CITY OF ALBUQUERQUE

**RE: Mister Car Wash
3535 Menaul Blvd. NE
Grading & Drainage Plan
Engineer's Stamp Date: 04/18/2025
Hydrology File: H16D083F
Case # HYDR-2025-00131**

Based upon the information provided in your submittal received 04/18/2025, the Grading & Drainage Plan **is not** approved for Building Permit and Grading Permit. The following comments need to be addressed for approval of the above referenced project:

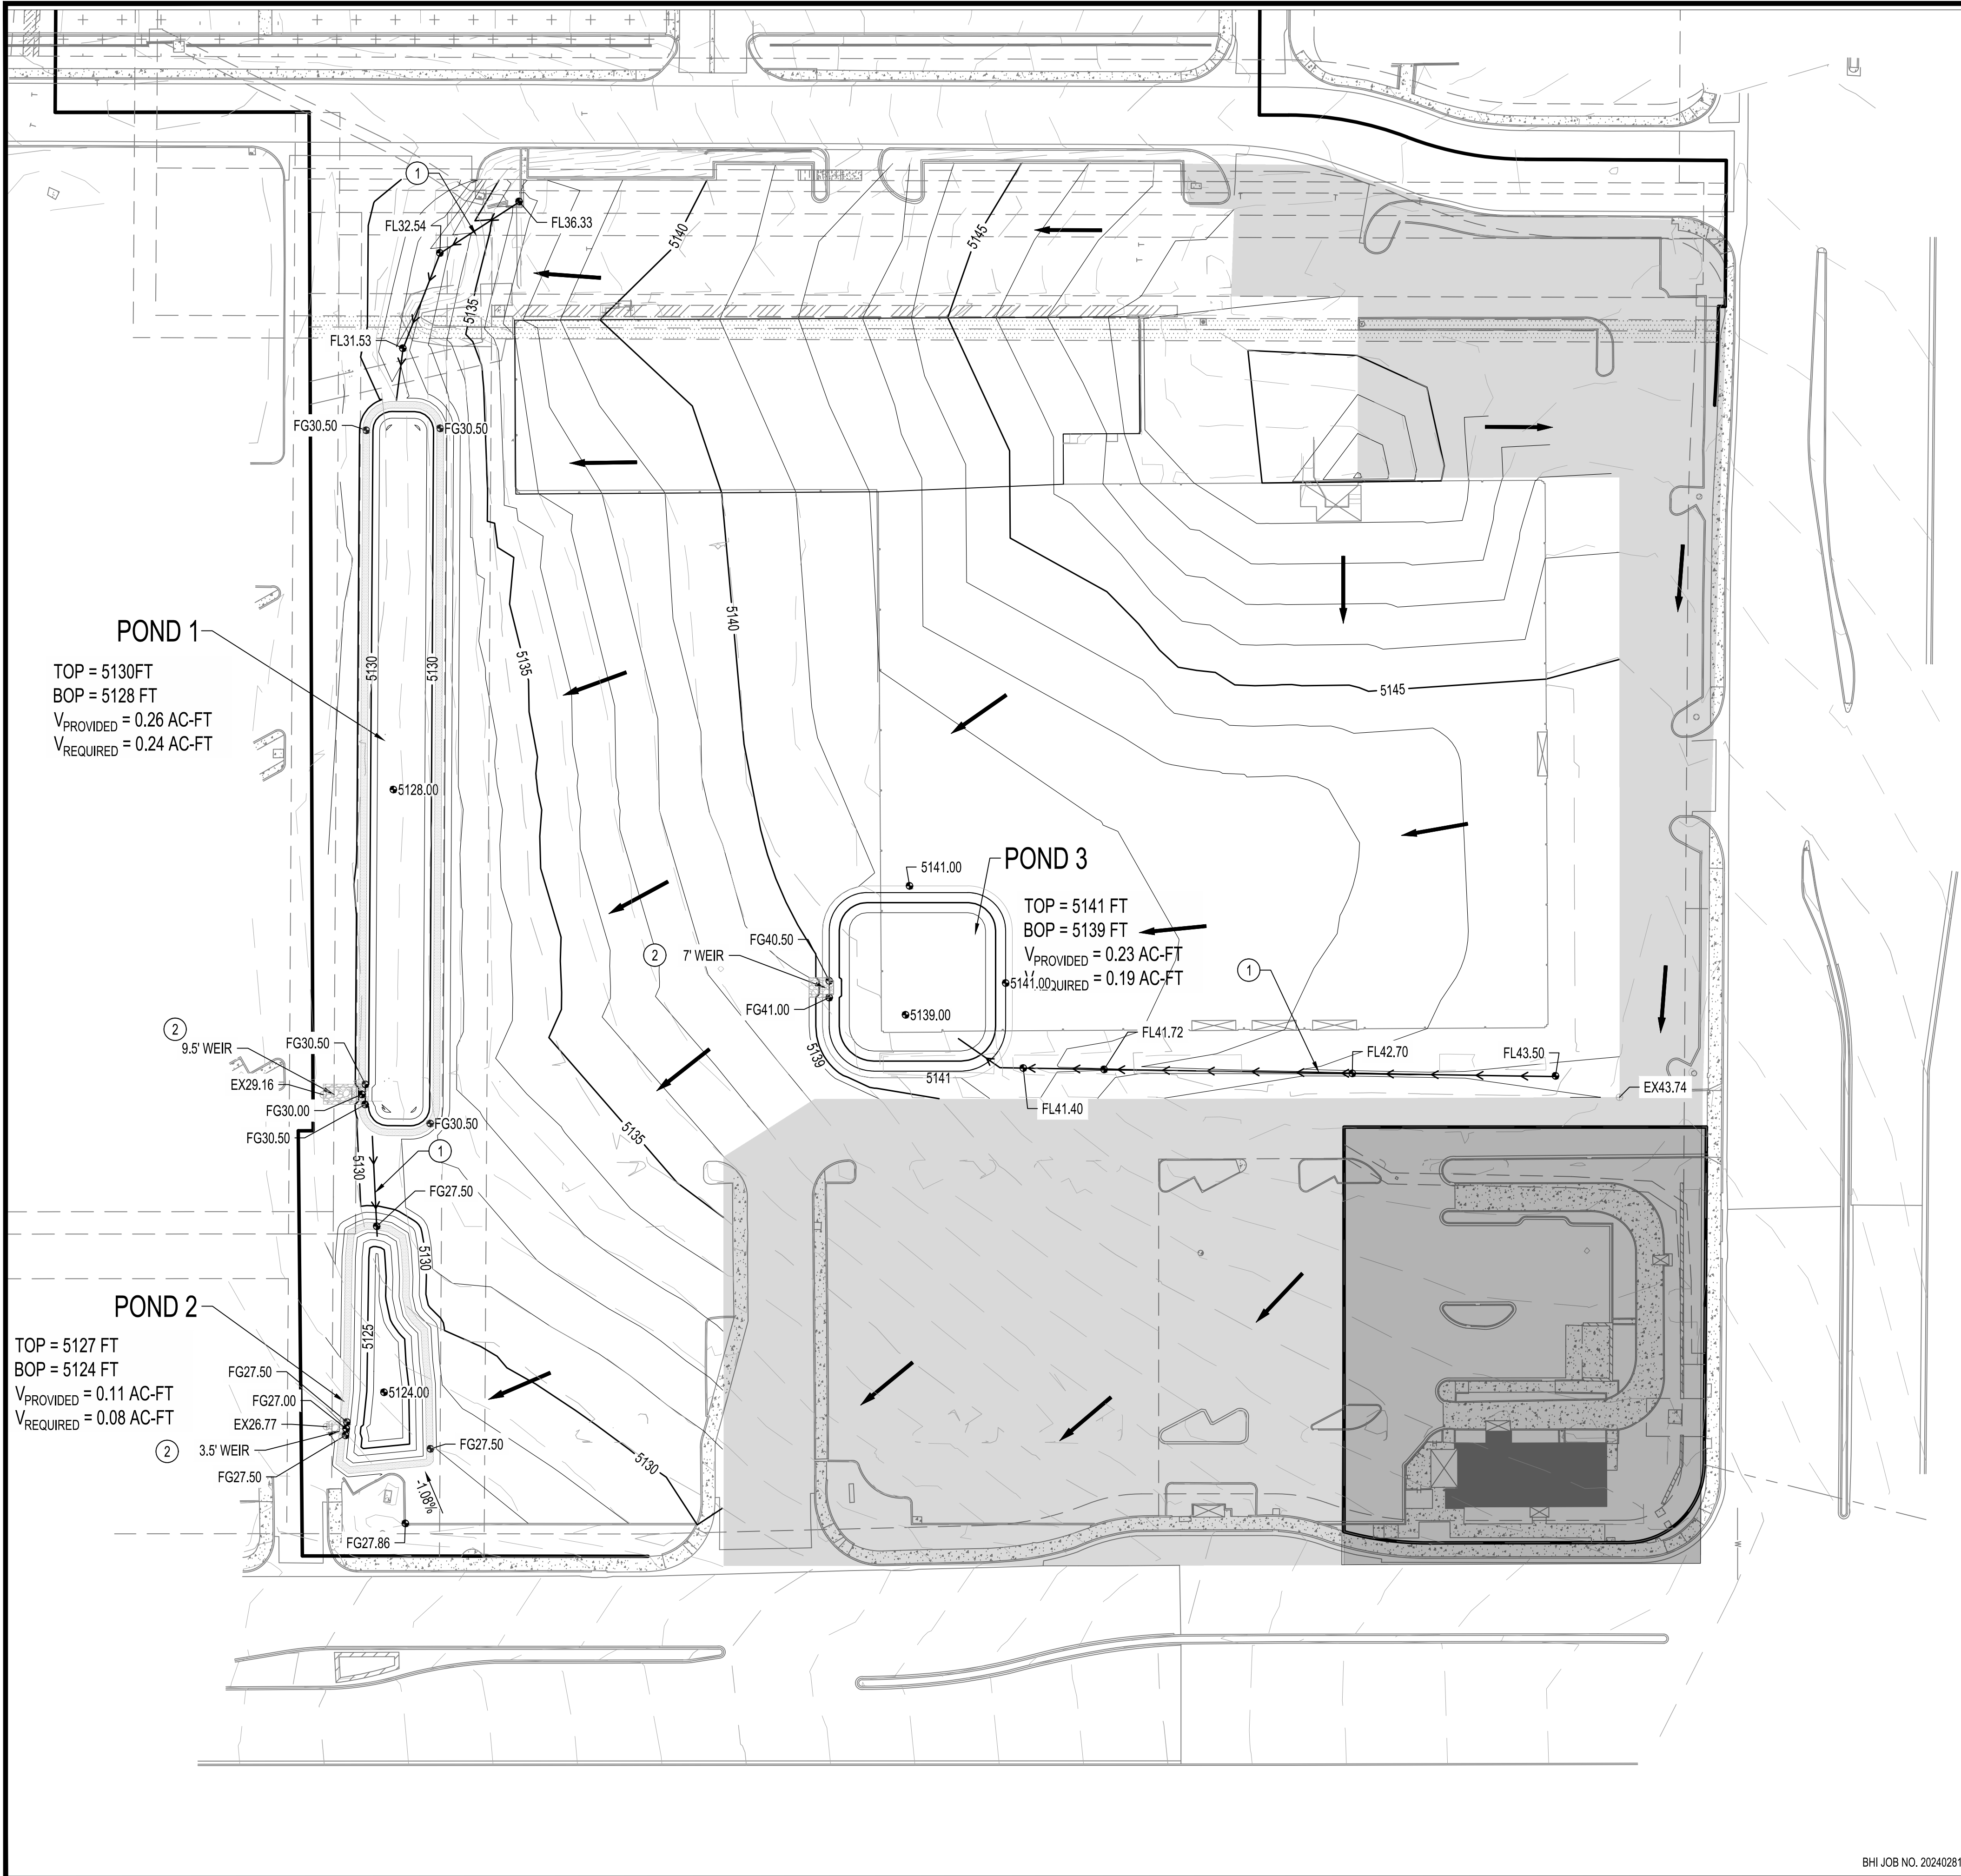
1. Please add a note which states, "The Owner has elected to pay the Payment in Lieu for the required Stormwater Quality Volume."
2. Please show the calculation for the required volume on the plan. This site qualifies as redevelopment and is only required to retain runoff from the 80th percentile storm (Vol. = 0.26"*Imp.Area).
3. Complete the application for the Waiver of SWQV and submit to Hydrology for review and approval.
